Address: Woodleigh Cottage, 2A Bryan Road Huddersfield HD2 2AH

Application number: 2024/44/90602/W	
What is the application for?:	Discharge conditions 3 (boundary fencing), 5 (cycle storage), 7 (Arboricultural)
Address of the site or building:	Bryan Wood Residential Home, 1, Bryan Road, Edgerton, Huddersfield, HD2 2AL
Postcode:	B60 4AD

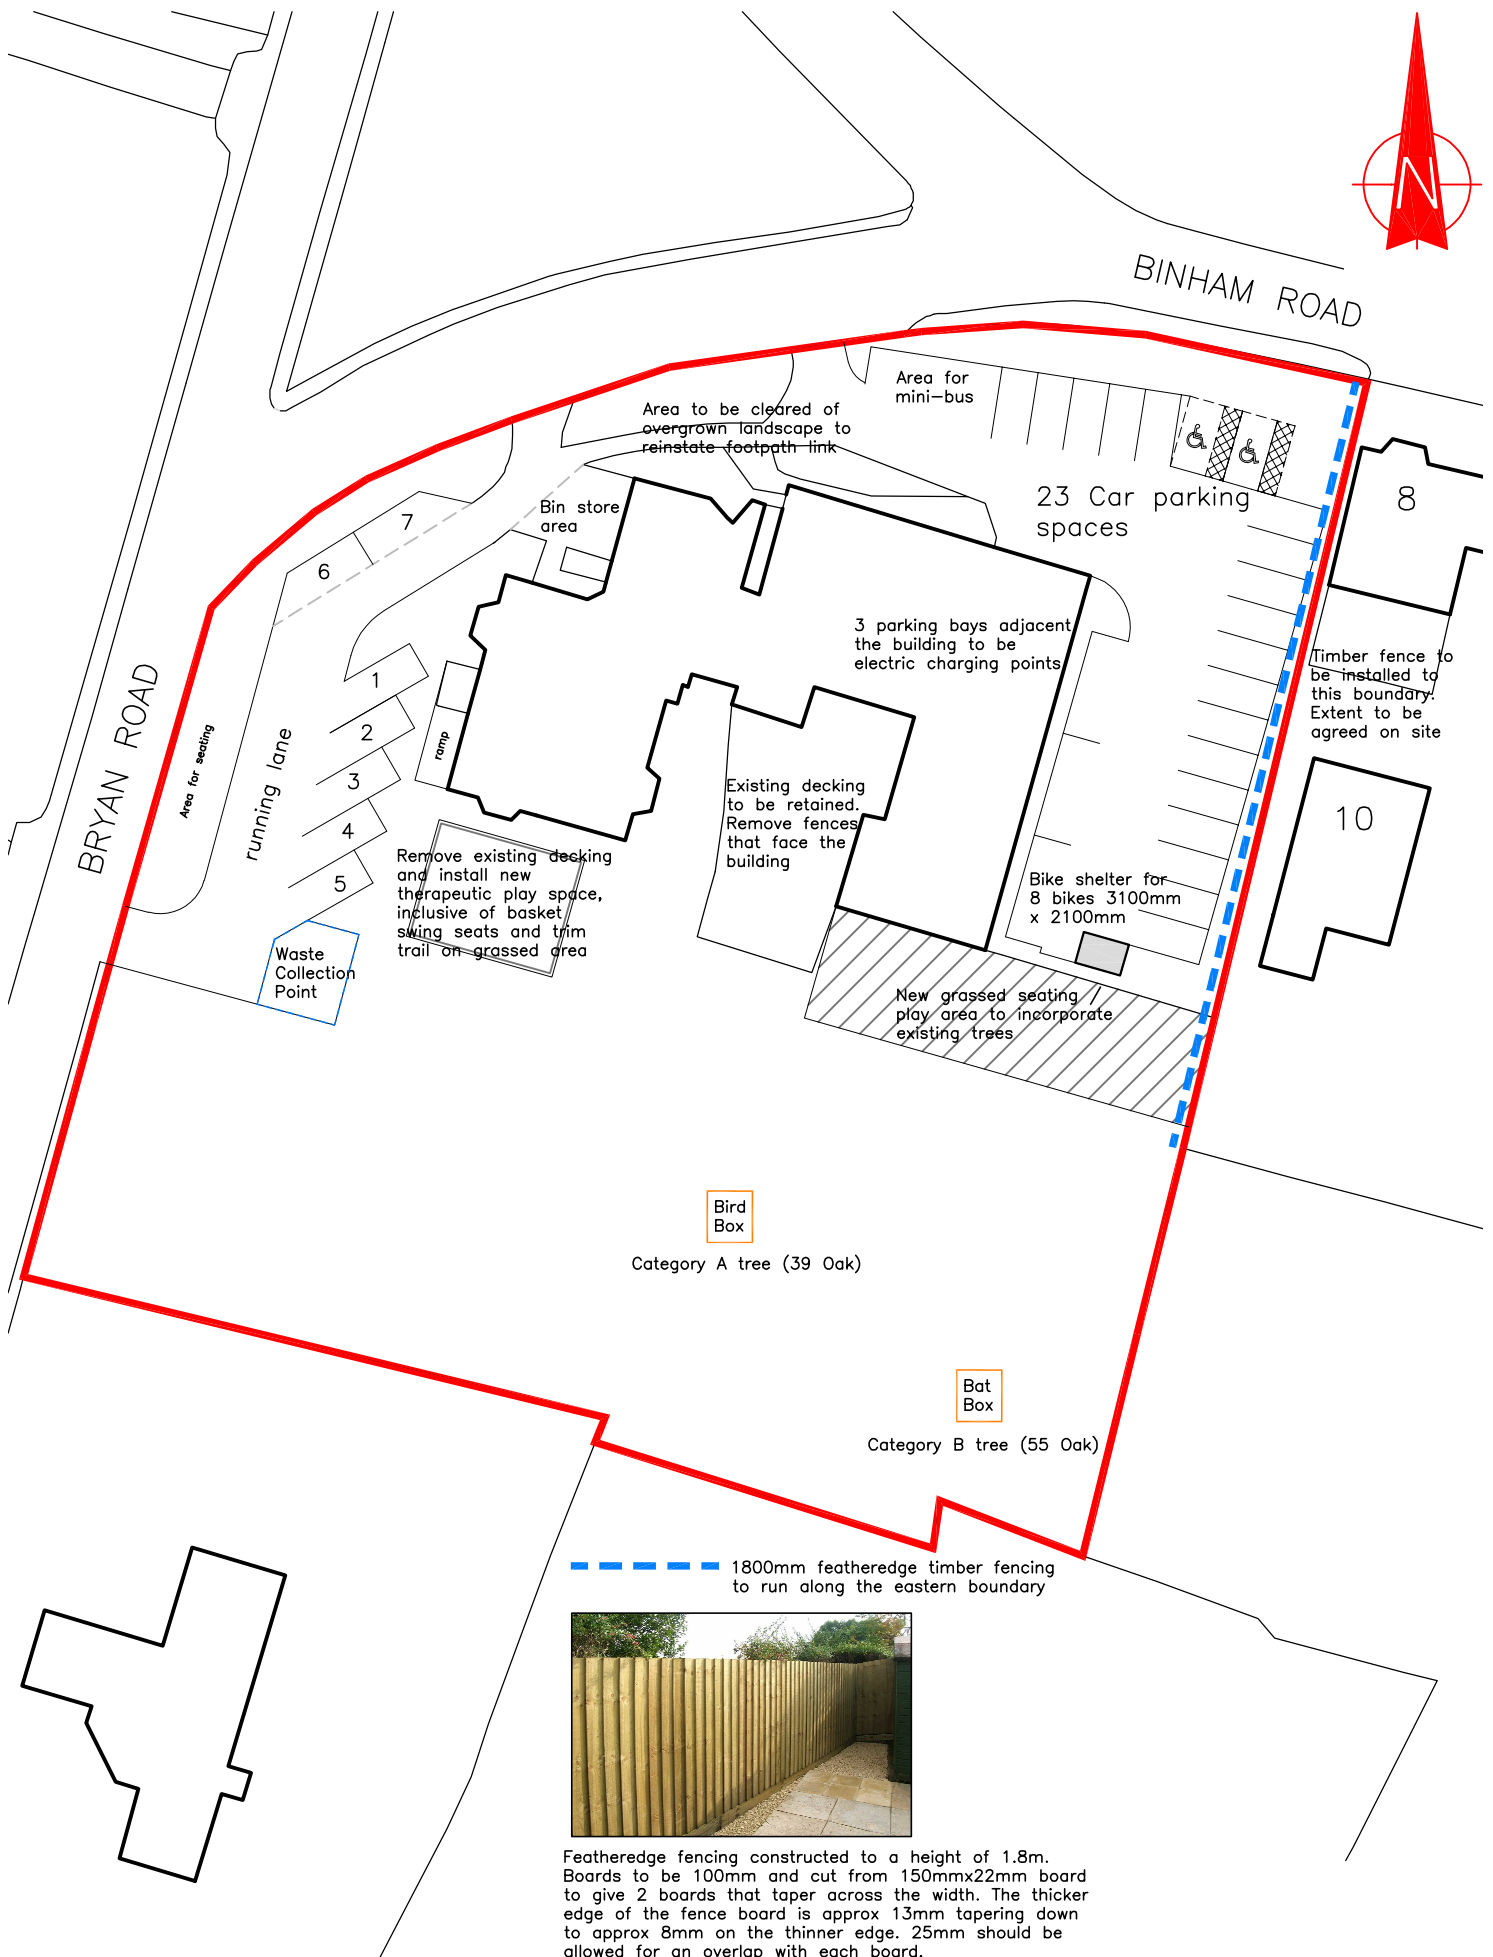
Type of comment: An objection	
Do you wish your comments to be published on the website anonymously?	No
<p>The original application 2022/62/92581/W showed the placement of the bins by the Binham Rd entrance but looking at this new discharge application 2024/44/90602/W it shows them to the front of the building on the right hand side immediately through the gateway ie right in front of our house. How will the bin collection wagon obtain entrance through the narrow gateway/between the gateposts or will it be parking up in front of our house on a weekly basis? This change has not been highlighted in the new discharge application and the original plan has been 'superceded' in the original application meaning we have only just managed to spot this change. Surely this is not allowed without consultation with any adversely affected parties and we would certainly like to object.</p>
